**KIRKLEES METROPOLITAN COUNCIL  
INVESTMENT & REGENERATION SERVICE**

| Reference No:         | <b>2026/62/90834/E</b>                                   |
| Site Address:         | 18, Fir Parade, Ravensthorpe, Dewsbury, WF13 3BH         |
| Description:          | Erection of single storey front, side and rear extension |

Drawing Title
Proposed Elevations

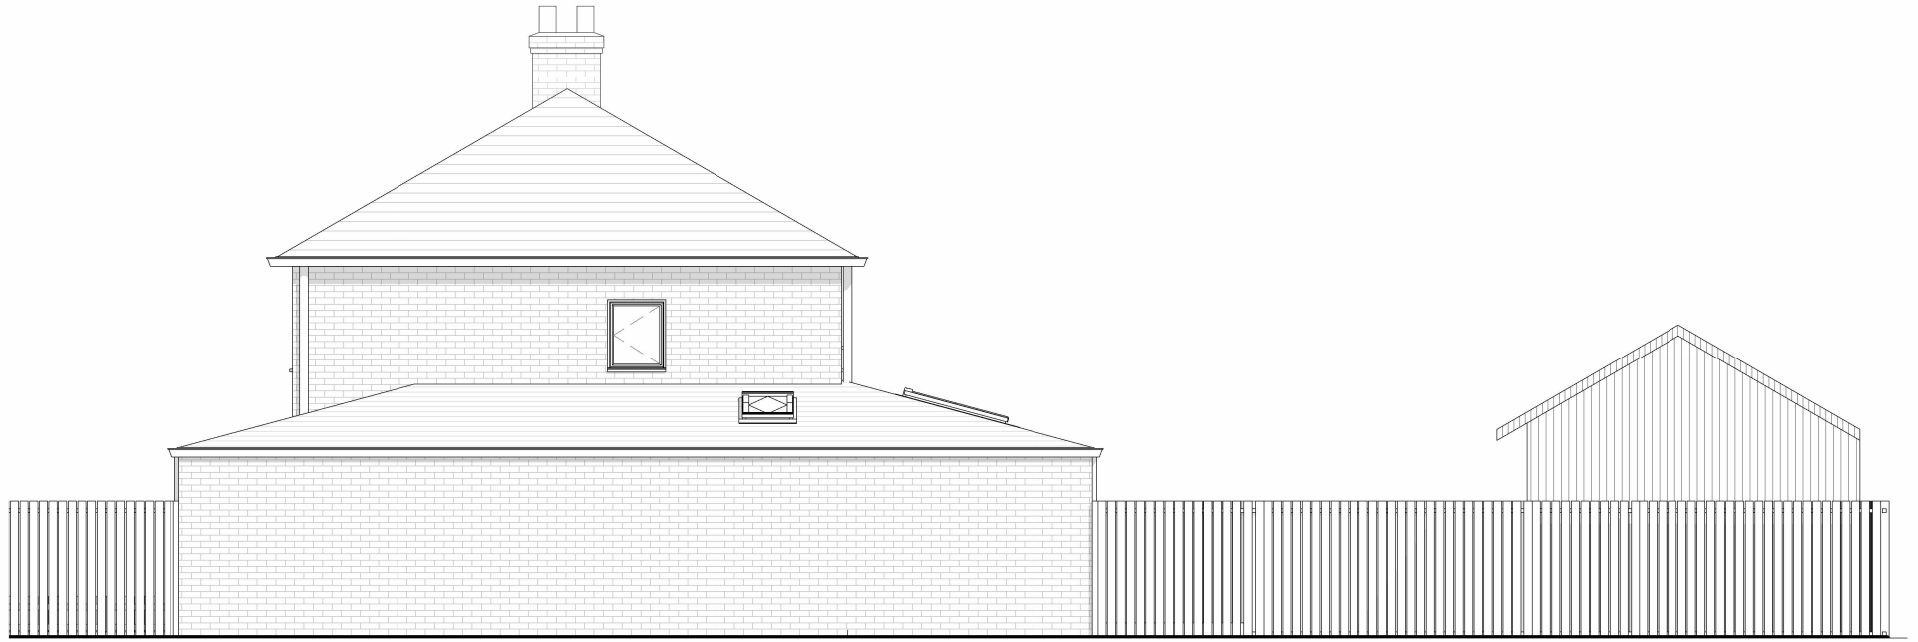
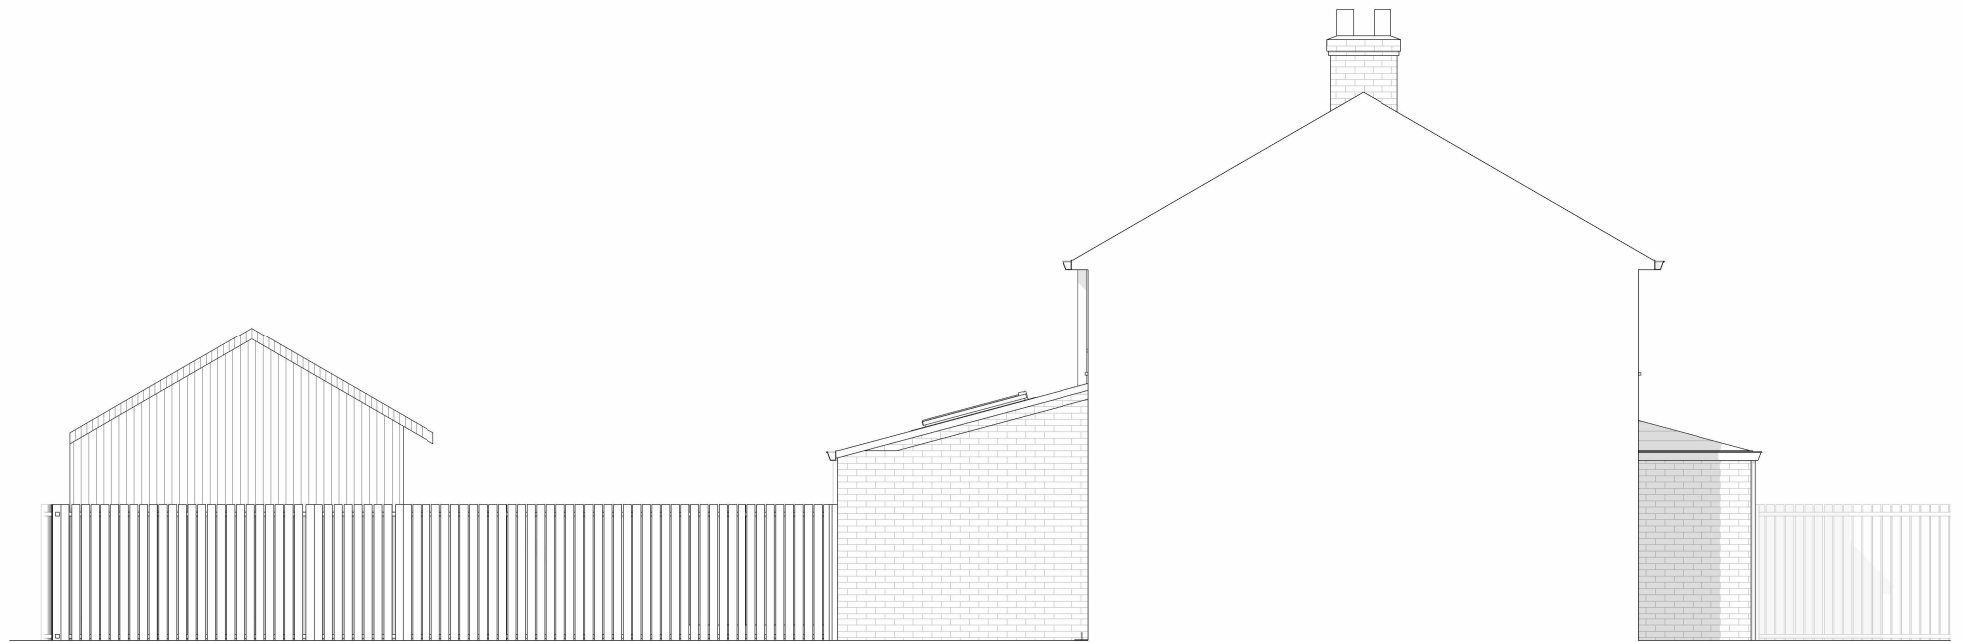
The proposed front extension projects approximately 1.5 metres from the principal elevation and span the full width of the dwelling. It would incorporate two new window openings, serving the extended living room and forming part of a proposed snug area.

The side extension projects approximately 3.1 metres from the original side elevation, extending to a depth of approximately 3.3 metres beyond the existing rear wall. The rear elevation of the side extension, facing the rear garden, would include a window serving a utility area.

The rear extension projects approximately 3.3 metres from the original rear elevation and span the full width of the dwelling. It incorporates a rear-facing window and a set of French doors opening onto the rear garden.

The proposed extensions will be constructed in brick, with a tiled roof to match the existing dwelling. The eaves height measure approximately 2.4 metres, and the extensions is designed with a hipped roof form incorporating rooflights.

The existing house is set sufficiently back from the pavement. The proposed extension is small, subservient to the original, well-designed and would not harm the character of the original house or the surrounding area. The front extension is therefore considered acceptable in terms of its impact on visual amenity.

The property currently benefits from an existing outbuilding located to the rear side, which would be removed to facilitate the proposed side extension. The proposed single-storey side extension would be set flush with the resultant front elevation of the dwelling and would project approximately 3.3 metres beyond the existing rear wall to wrap around into the resultant rear extension.

The extension is modest in scale and would be constructed using materials to match the existing dwelling, thereby ensuring a cohesive appearance. The design is considered appropriate and would not appear incongruous within the street scene. Whilst the House Extension SPD does suggest there should be 1m set in from the side boundary, in this instance, as there are other such extensions in the area, the lack of set in from the boundary is considered to be justifiable as it will be similar to those in the building group.

The proposed single-storey rear extension would project approximately 3.3 metres from the original rear elevation of the dwelling. The extension is modest in scale and would be constructed using materials to match the existing dwelling, thereby ensuring a cohesive appearance.

Number 20 Fir Parade is the adjoining semi-detached property. The proposed front extension would be situated over one metre from the nearest window serving this neighbouring dwelling and would project approximately 1.5 metres from the principal elevation. As such, it would not result in any unacceptable overlooking, overshadowing or overbearing impact, and would not conflict with the 45-degree guideline.

The rear extension would be constructed up to the boundary line; however, given its modest height, mono pitched roof, and limited projection, it is considered that there would not be any significant overlooking, overshadowing or overbearing impact on the neighbouring occupiers.

Number 16 Fir Parade is located to the south-east of the application site. The proposed side extension would be constructed close to the shared boundary; however, the side elevations of No.16 is already located adjacent to the existing two-storey side elevation of the host dwelling. Whilst the proposal would introduce additional built form along the boundary, this would comprise a single storey extension, with a modest eaves height and mono pitched roof. Consequently, it is not considered that the proposal would materially worsen the existing relationship between the properties or result in an unacceptable overbearing, overshadowing or enclosing impact upon the occupiers of No.16.

The proposed extension contains no side-facing habitable room windows towards No.16 and therefore would not give rise to unacceptable overlooking.

With regard to the front and rear extensions; notwithstanding the way No.16 is shown on the proposed plans, this dwelling has been subject to a part two/part single storey rear extension. As such, it is not envisaged that the proposed rear extension would cause an adverse impact on the amenity of the neighbour, given the separation distance, modest depth and height. The proposed front extension would be of limited depth and height, located sufficiently away from habitable room windows as such, it is not considered that this element would have amenity impacts.
